Memorandum

To: Kittitas County Public Works
From: Jeff Johnson, P.E.
Date: June 6, 2013
Re: Black Horse Subdivision – Flood Risk Review

Watershed Science & Engineering (WSE) was asked by the Kittitas County Department of Public Works to provide an independent general review of potential flood risks that may impact the proposed Black Horse at Whiskey Creek residential subdivision development. The subdivision is located northwest of the City of Ellensburg on an undeveloped 80 acre parcel that is bordered by three county roads and an undeveloped parcel to the west (Figure 1).

File: \\Esm\ENR\ESM\005\410\_028\PP-plan\A\A\A\PP-03.dwg  
 Printed: 5/17/2006 2:30 PM  
 Plotted By: Jeff Hines

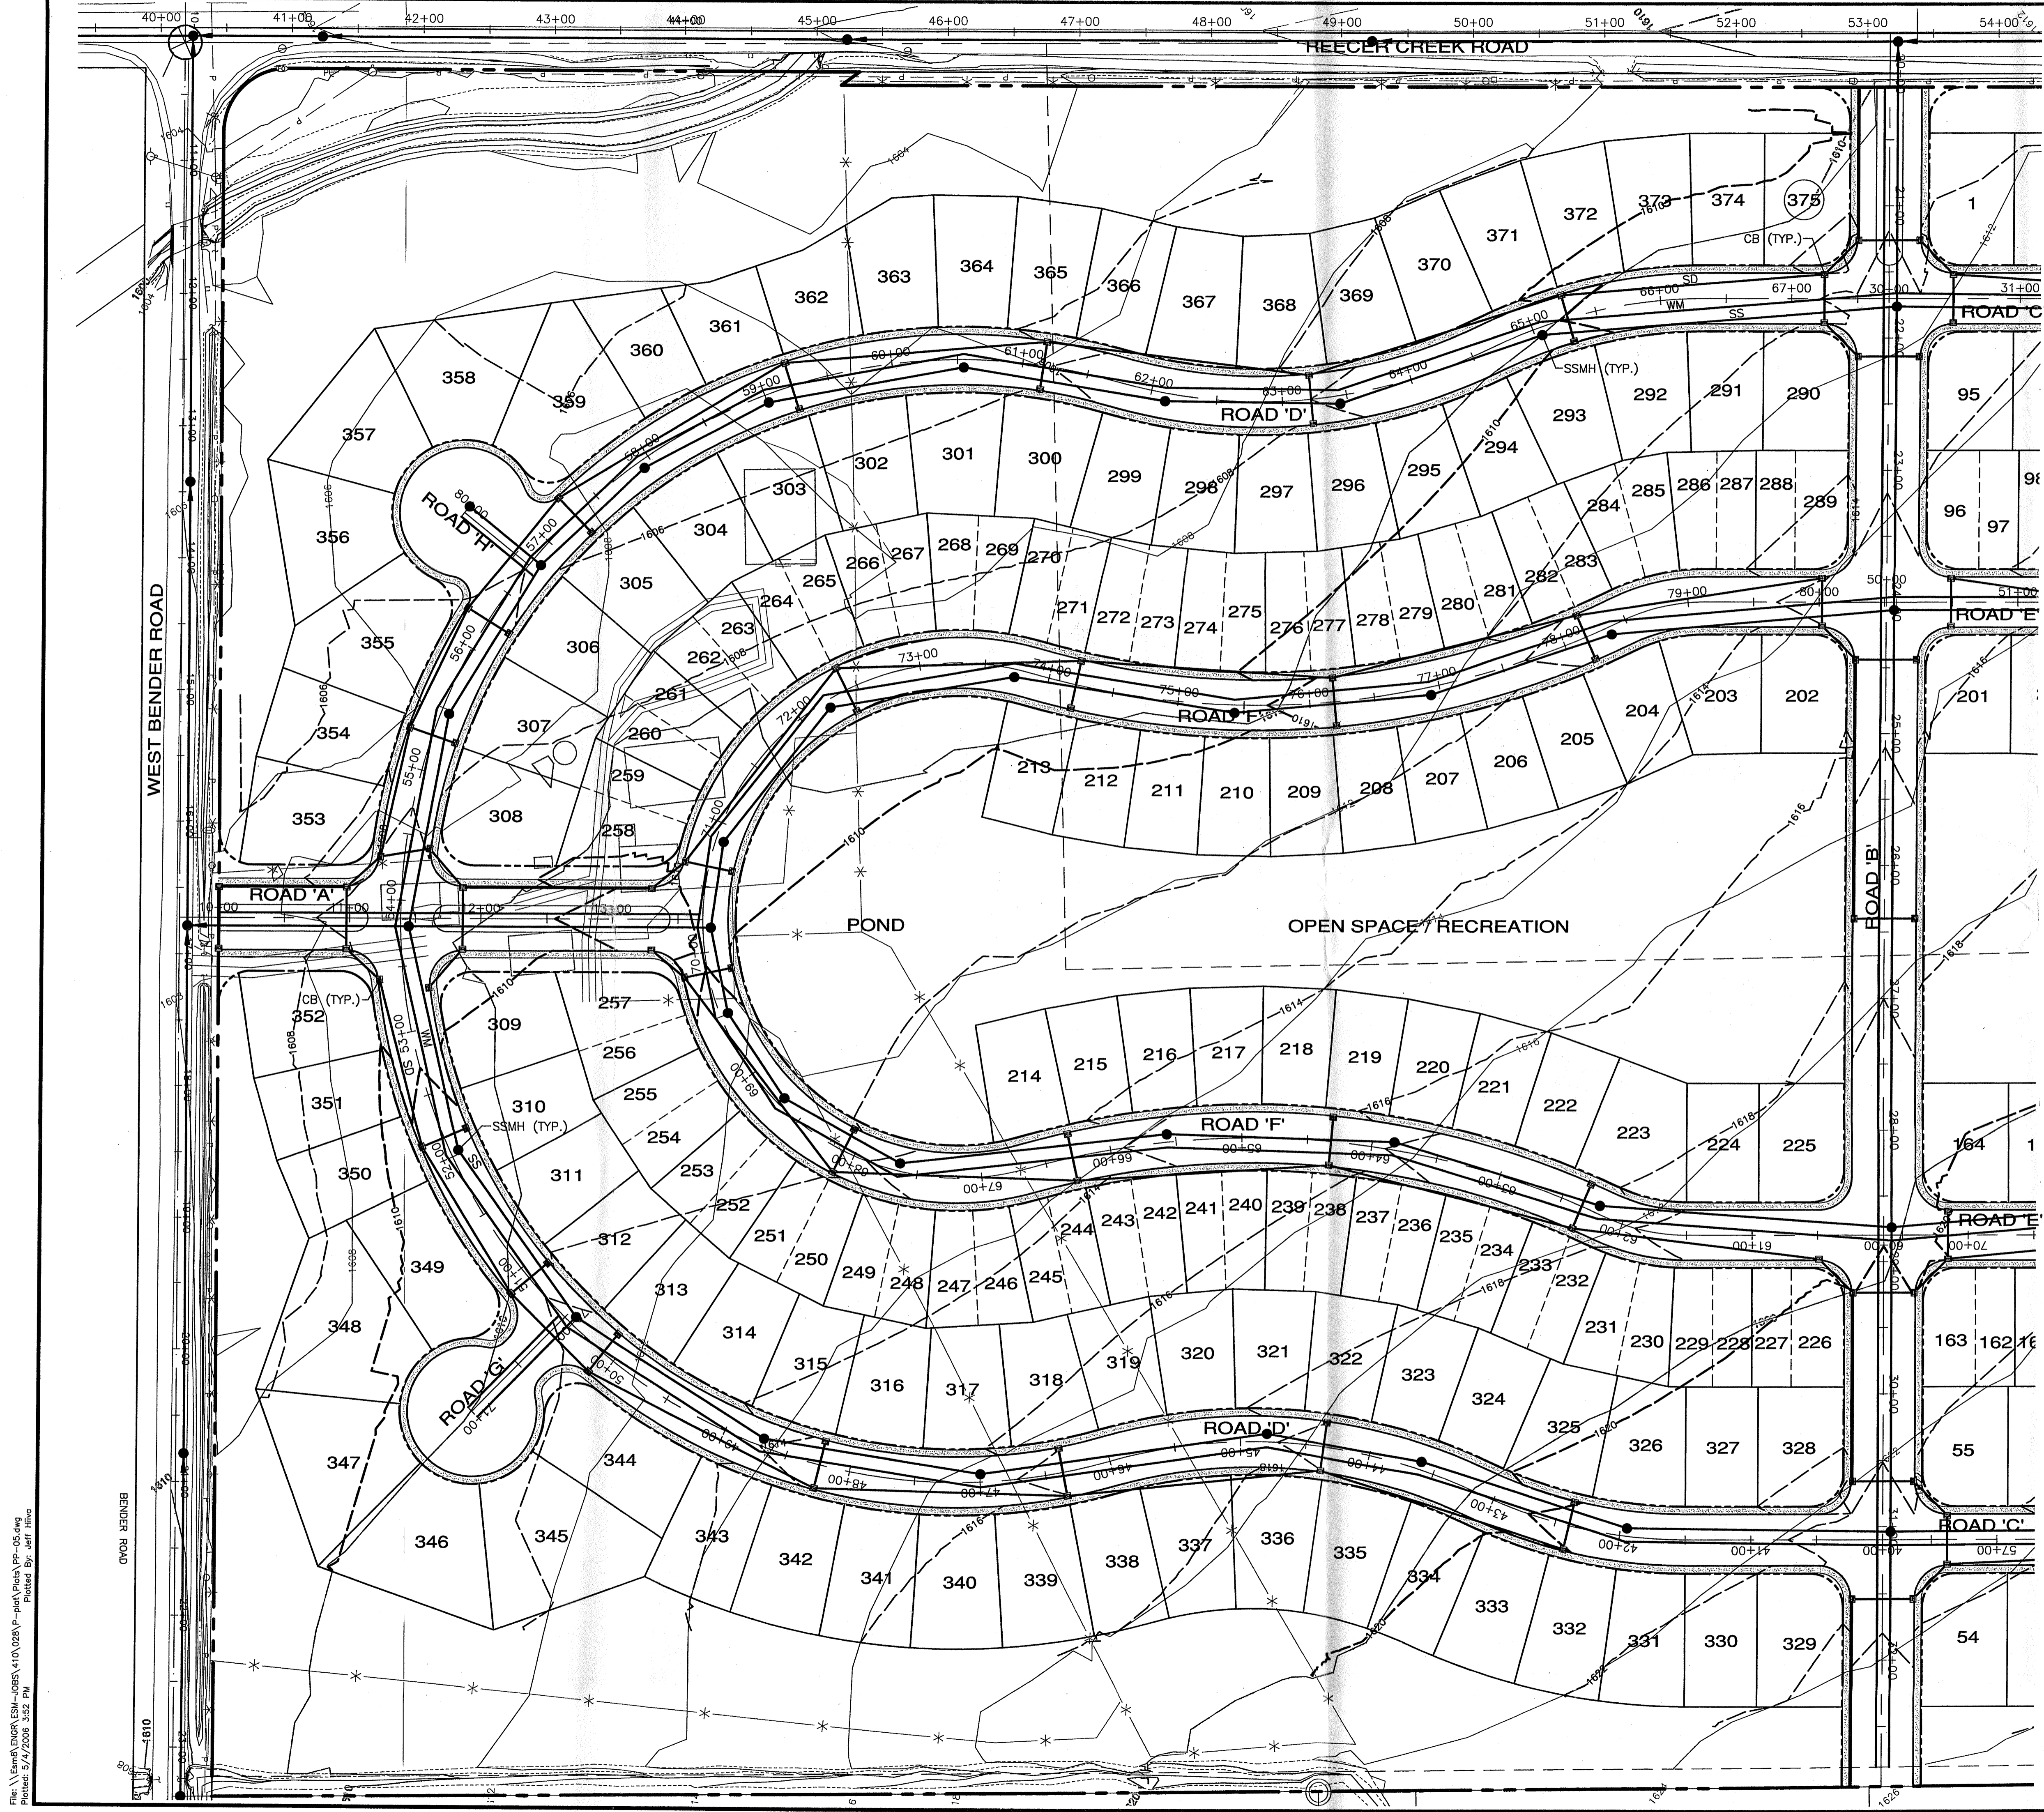
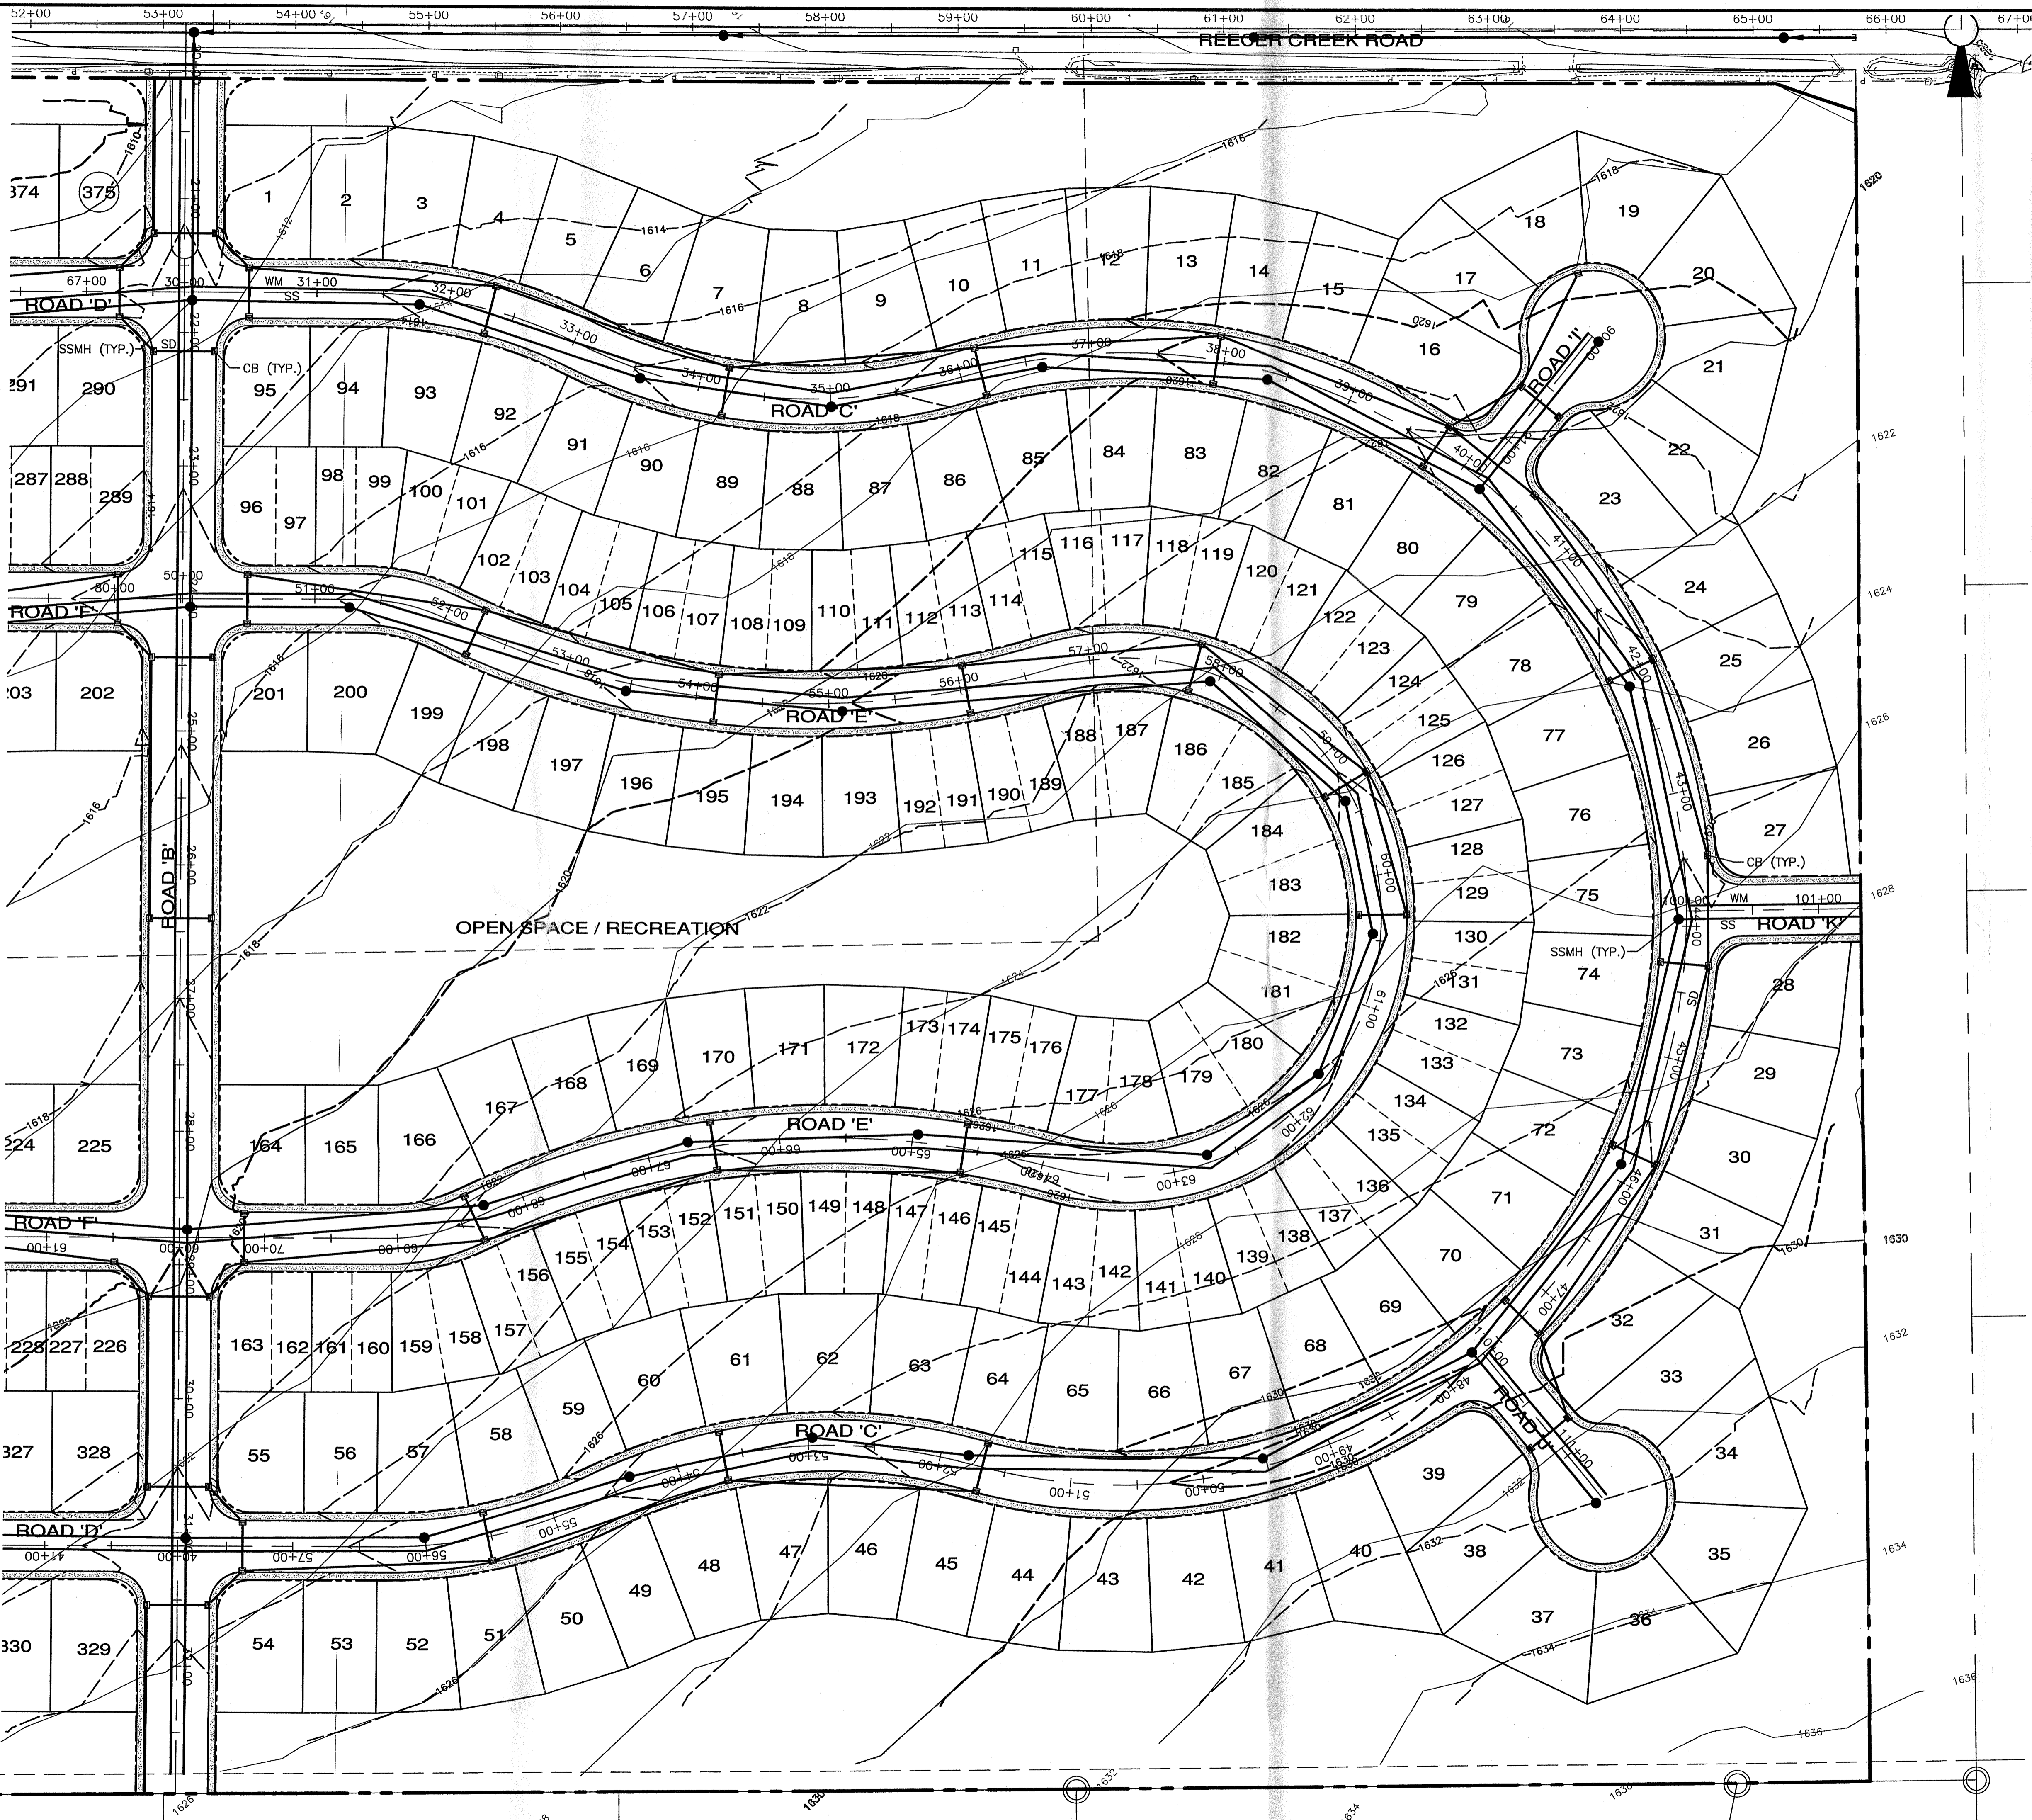
4. The focus of the flood mitigation work for the development has been on the risks Whiskey Creek poses to the southeast corner of the development. It appears however, that there may be an under-appreciated flood risk to the portion of the development that borders Reecer Creek Road. The design calls for a relatively small ditch to be constructed between Reecer Creek Road and the subdivision. We are concerned that the ditch may be too small to convey the volume of water that may enter the area during a major flood. We are also concerned that there does not appear to be a large culvert to carry the ditch under 29th Avenue, the entrance road into the subdivision from Reecer Creek Road. Our concern arises from examining the LiDAR hillshade image presented in Figure 2, the partial subdivision plan set, and from observations made by County staff during previous floods.

- a. As shown by the blue arrows in Figure 2, it appears that that flood water can leave Whiskey Creek just downstream from the Cascade Irrigation Canal and flow overland to the west, bypassing the Bowers Road Whiskey Creek crossing. This water will eventually be intercepted by the Bowers Road fill and directed west toward the intersection of Bowers and Reecer Creek Roads. At the intersection the water will over top both Reecer Creek Road and Bowers Road. The water that overtops Bowers Road will enter the road side ditch between the development and Reecer Creek Road. The volume of water entering the ditch could be large and may overwhelm the proposed ditch. This could result in flooding of the proposed sediment/detention ponds, 29th Avenue, low lying home lots that border Reecer Creek Road, etc.

- b. Flood waters may also originate from the Cascade Irrigation Canal. During floods, irrigation canals of this type intercept and convey flood water. During large storms, canals often do not have the capacity to convey all of the flood water and a portion of the flow overtops or breaches through the embankment that contains the canal. If this were to occur upstream from the subdivision, large quantities of water may enter the ditch along Reecer Creek Road. This may be an unlikely event, but it is a risk and therefore should be examined.

- c. According to the County, during the May 2011 flood, a large volume of water was conveyed along the subdivision side of Reecer Creek Road. To reduce flooding during the event, the County removed several gravel driveways that provided access into the Black Horse development site from Reecer Creek Road.

- d. The flood water that is conveyed along the subdivision side of Reecer Creek Road will enter the Town Ditch at the southwestern corner of the development. It is unclear how this would impact the Town Ditch and areas downstream along the ditch, or the adjacent portion of the subdivision.

Based upon the points above, it is our opinion that the flood risk along Reecer Creek Road has not been adequately evaluated. We recommend that a thorough investigation of flood risk be undertaken to determine if design revisions are needed to provide adequate flood conveyance facilities along the subdivision side of Reecer Creek Road. This investigation will need to include a thorough field inspection of potential overflow routes from Whiskey Creek and an assessment of the risk posed by the irrigation canal.
